From: Gavin Rossner [REDACTED]
Sent: 20 April 2021 13:27
To: Anita Gardner <Anita.Gardner@arun.gov.uk>
Cc: Simon Rolison [REDACTED]
Subject: FW: FW: Planning Consultation on: CM/11/21/DOC

Subject: RE: FW: Planning Consultation on: CM/11/21/DOC

Condition 11- Surface Water Drainage Design

Proposed Impermeable Areas - Scale 1:500

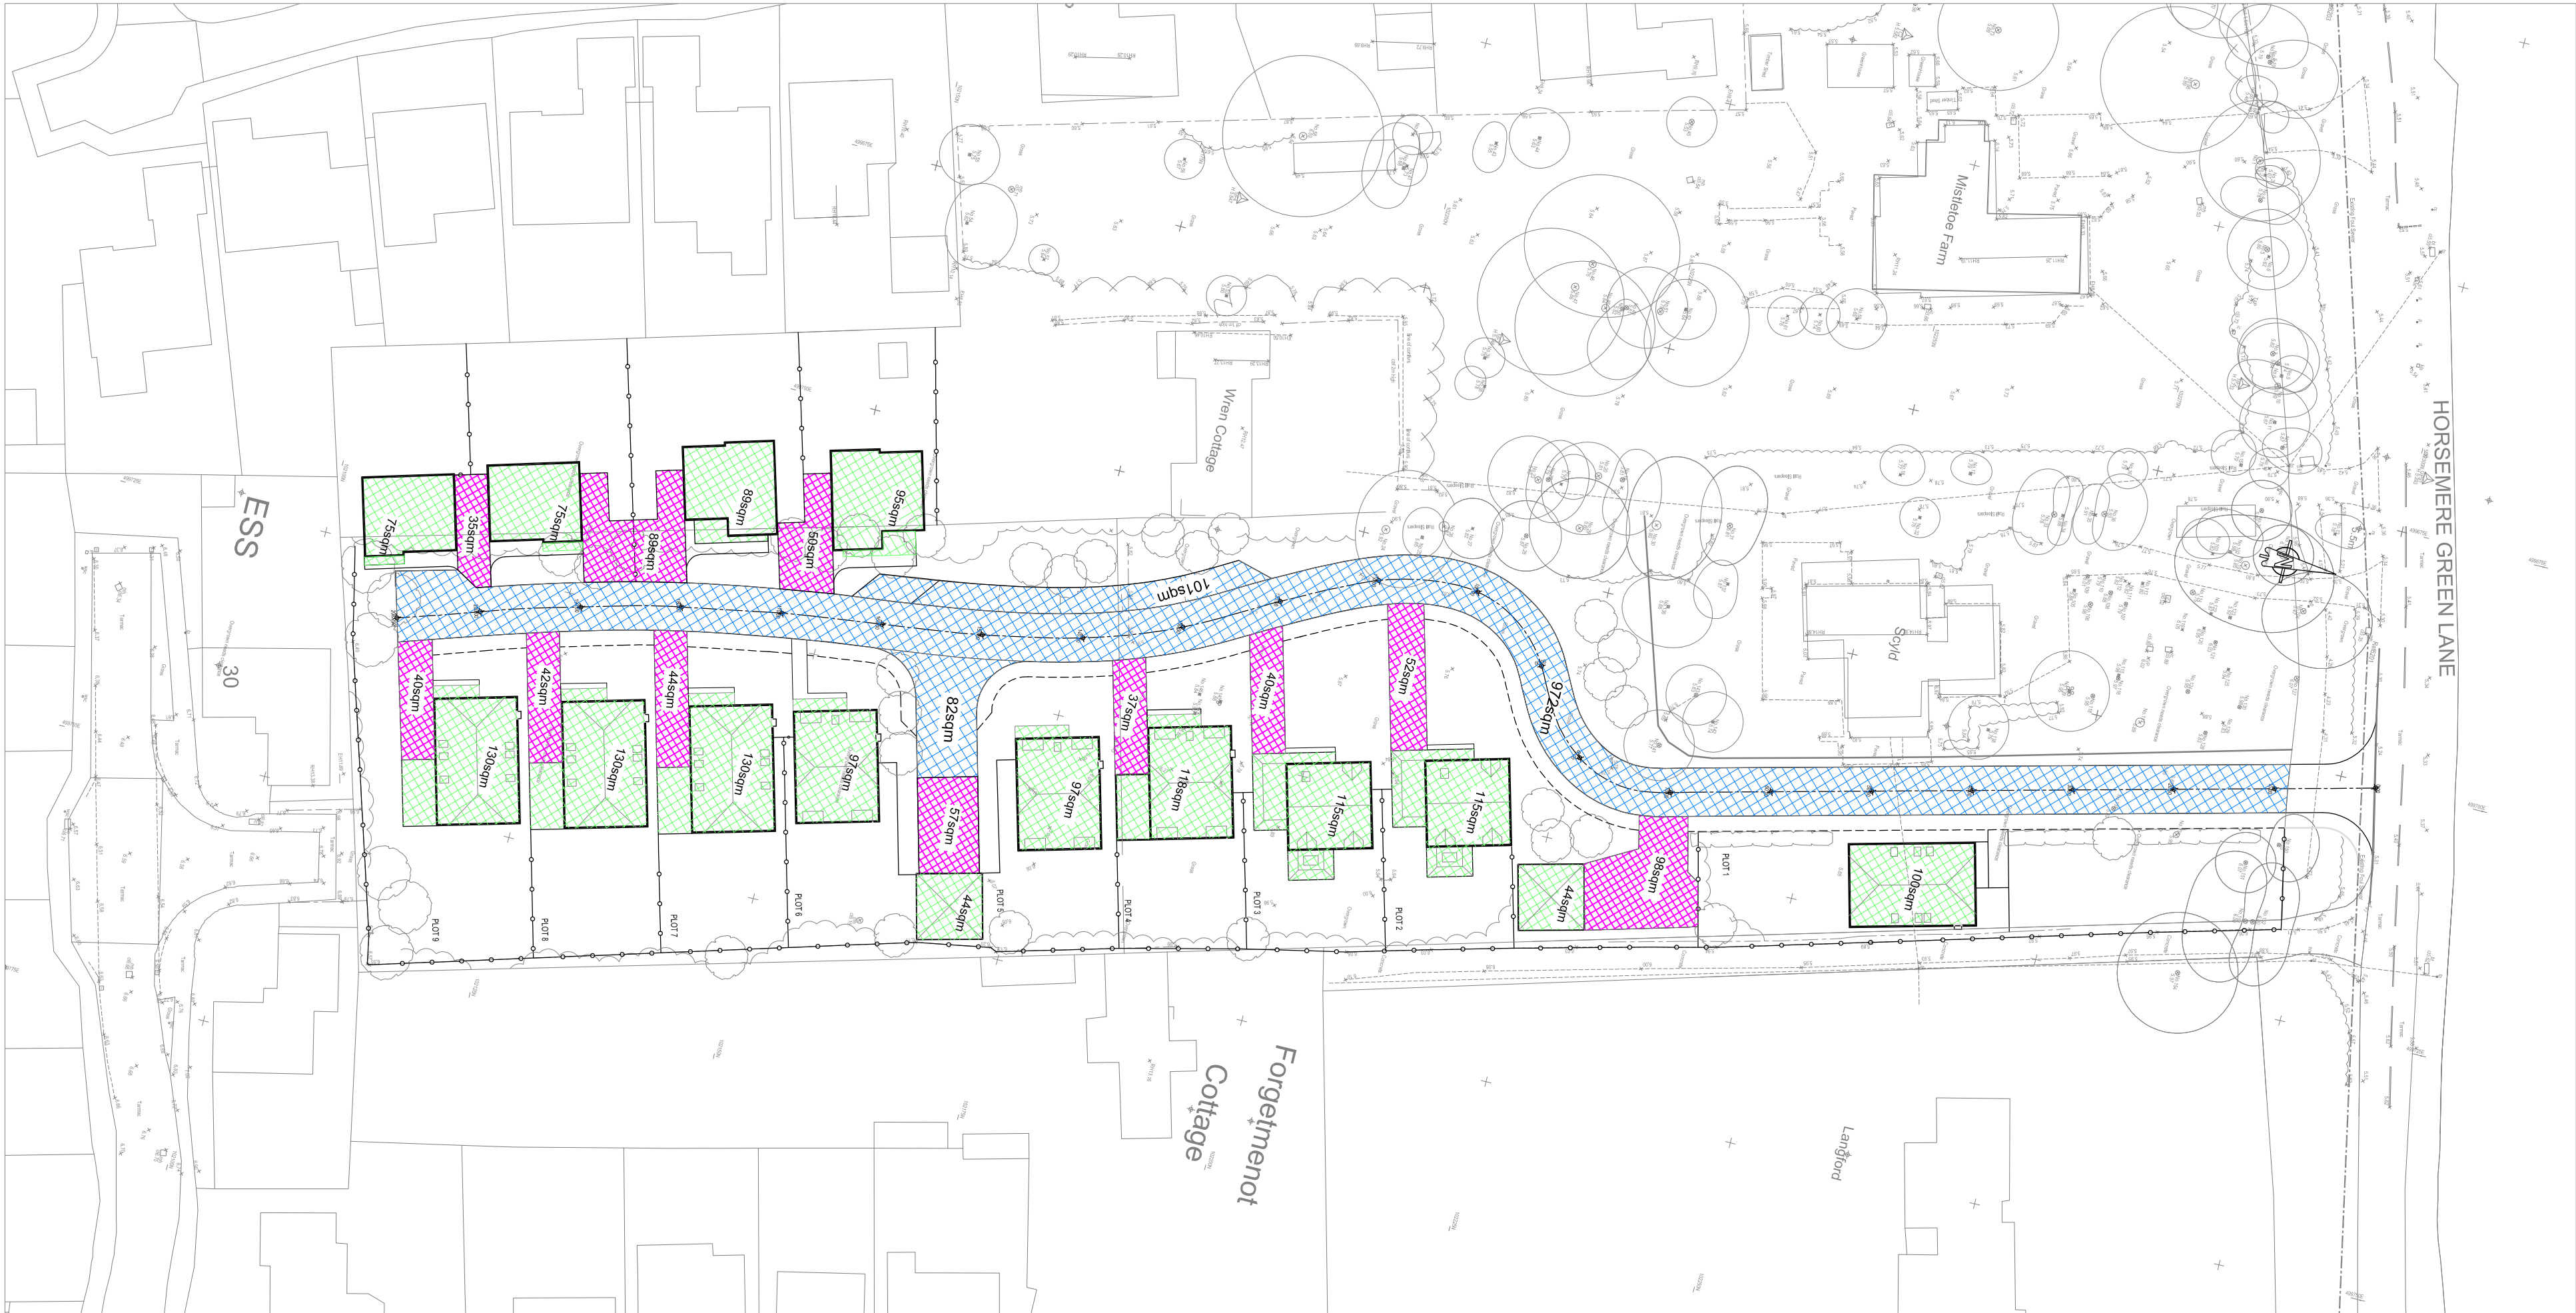
2. The impermeable areas plan appears to use an old layout, not the latest layout as approved under CM/55/20/PL. Please provide an updated impermeable areas plan. Updated plan attached to be read alongside the new calculations / drainage modelling. *Okay, point closed.*

DETAIL 1: TYPICAL SECTION SHOWING NEW ENTRANCE AND EXISTING HIGHWAY WITH NEW CULVERT

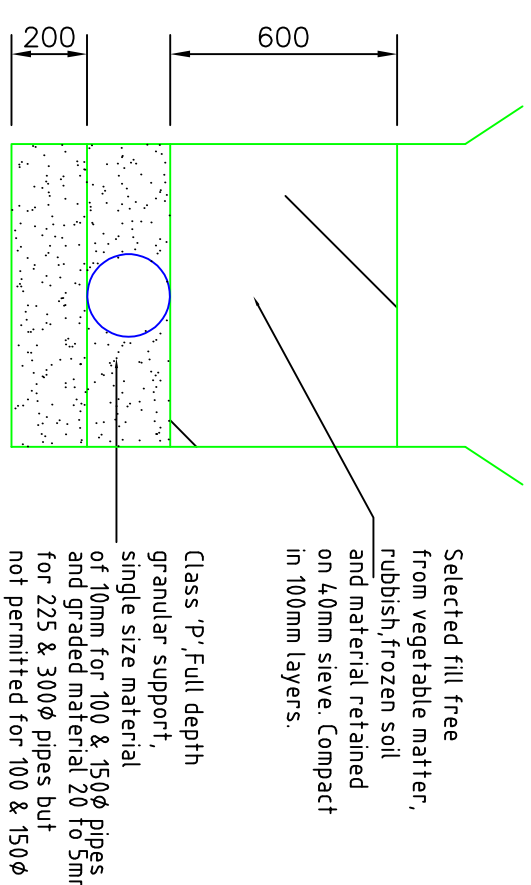
1. Please supply further details of the proposed culvert, i.e. diameter, invert level, and construction details- including headwalls. *We have put more information on the drawing on the details drawing. Two sets of drainage details sheet 2 have been provided, please confirm which version should be reviewed.*
2. It is stated on the plans that the culverting has been agreed, we do not believe this to be the case. Please supply evidence that an application for land drainage consent has been made for both the proposed culverting and outfall headwall. This has been applied for and we are issuing new information and the application is ongoing. *Okay.*

HEADWALL STRUCTURE FOR OUTLET PIPE

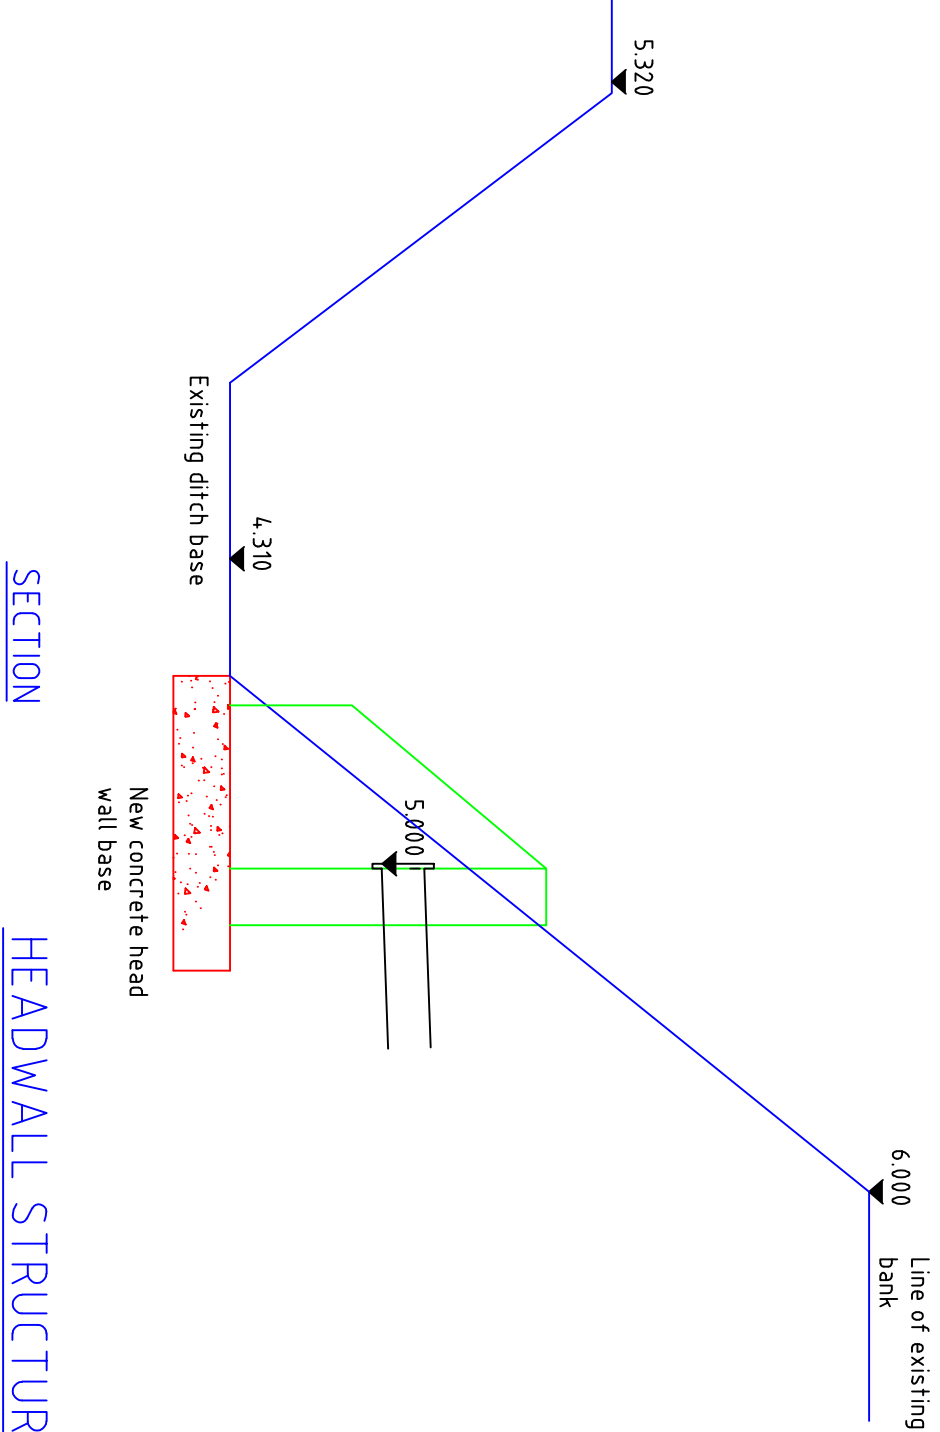
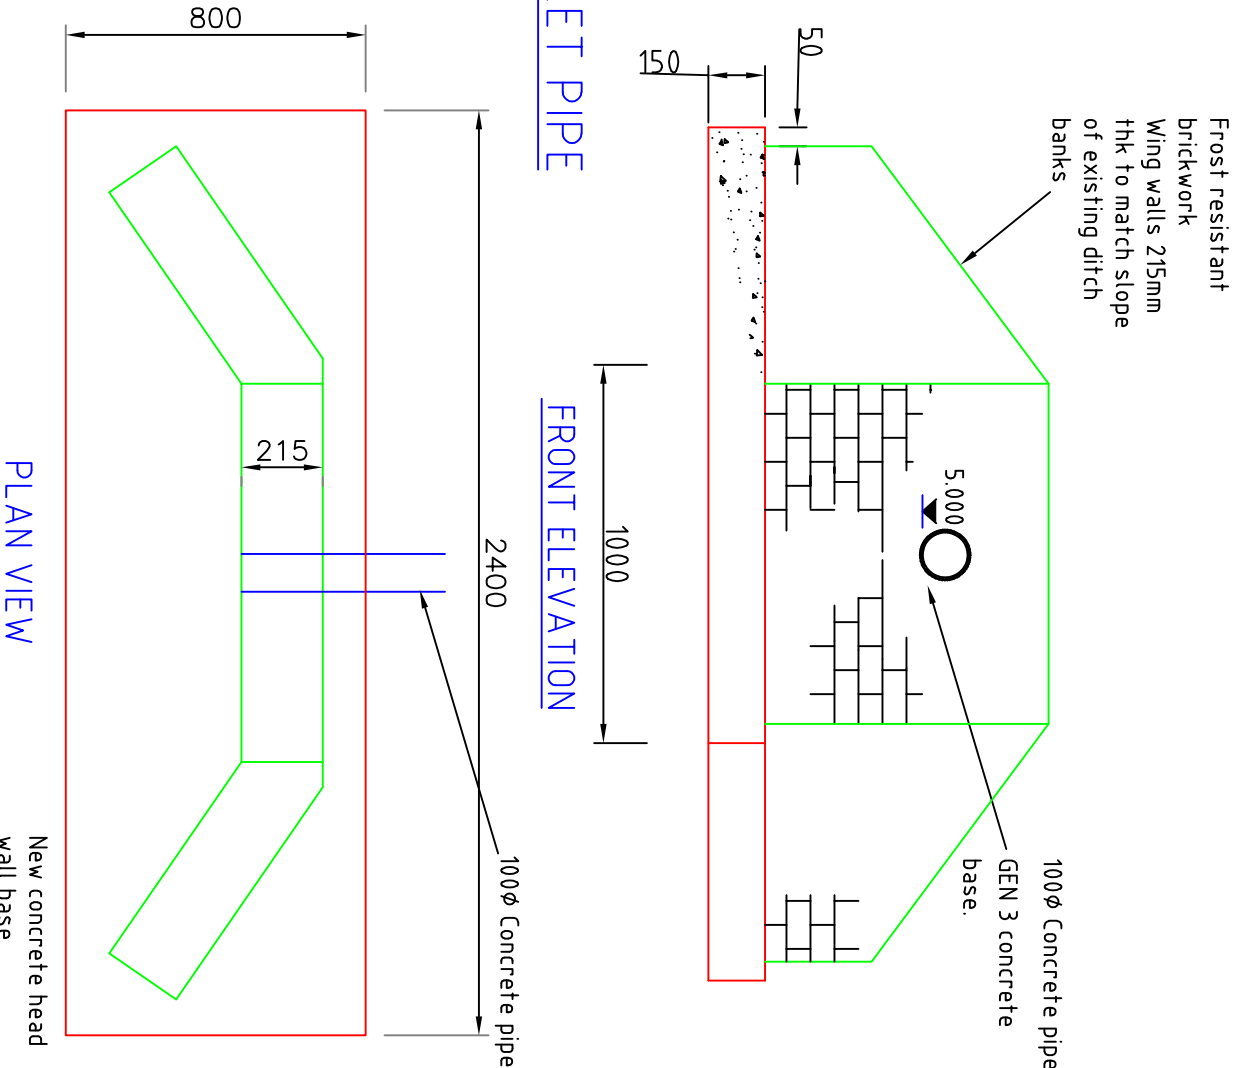
1. No connections are shown to/ from the permeable car park areas. We have now shown a connection into the storm drainage system.
7. Please provide site specific construction detail drawings of the proposed headwall, this should include a plan and full cross section through the ditch. All headwall drawings should indicate existing bed level, and top of bank level. Detail updated. *Two sets of drainage details sheet 2 have been provided, please confirm which version should be reviewed.*

CATCHPIT INSPECTION CHAMBER INCORPORATING FLOW CONTROL AND DEBRIS DEVICE

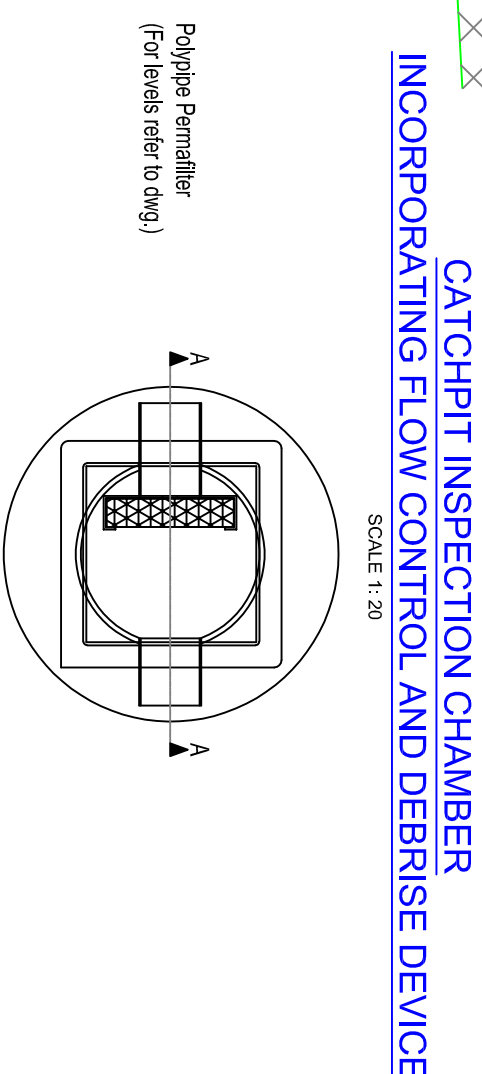
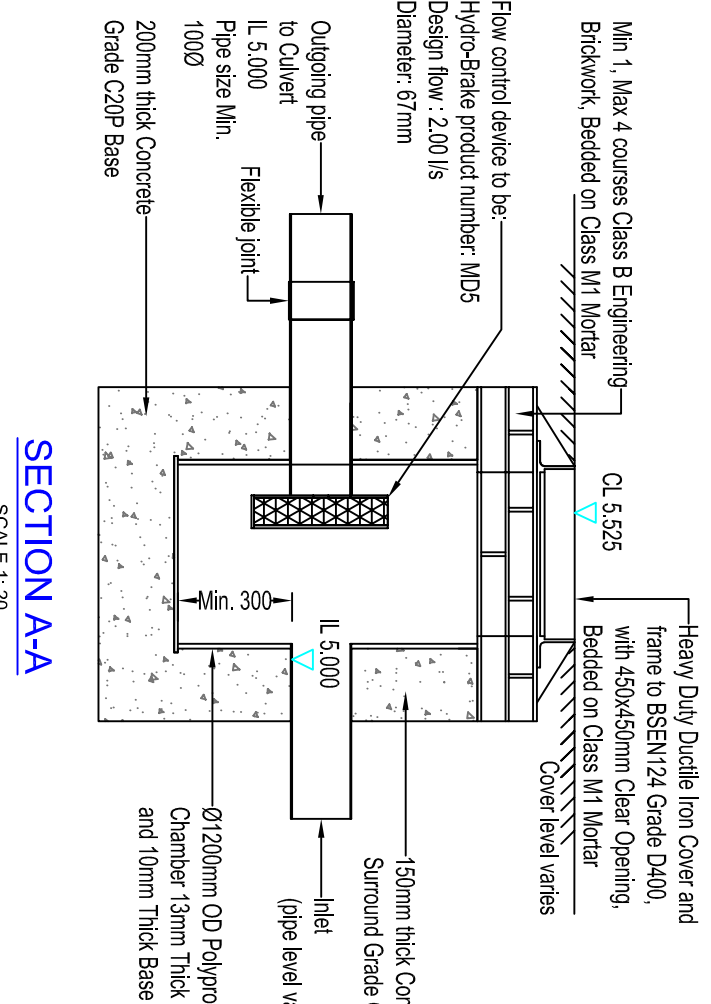
3. The long section on the drainage details sheet 1 refers to a hydrobrake with a restriction of 2.0l/s, which conflicts with the calculations, other details and layout (although addressing point 1 will affect these). This is now correct after the revised calculations, other details have been updated accordingly. See comment below.
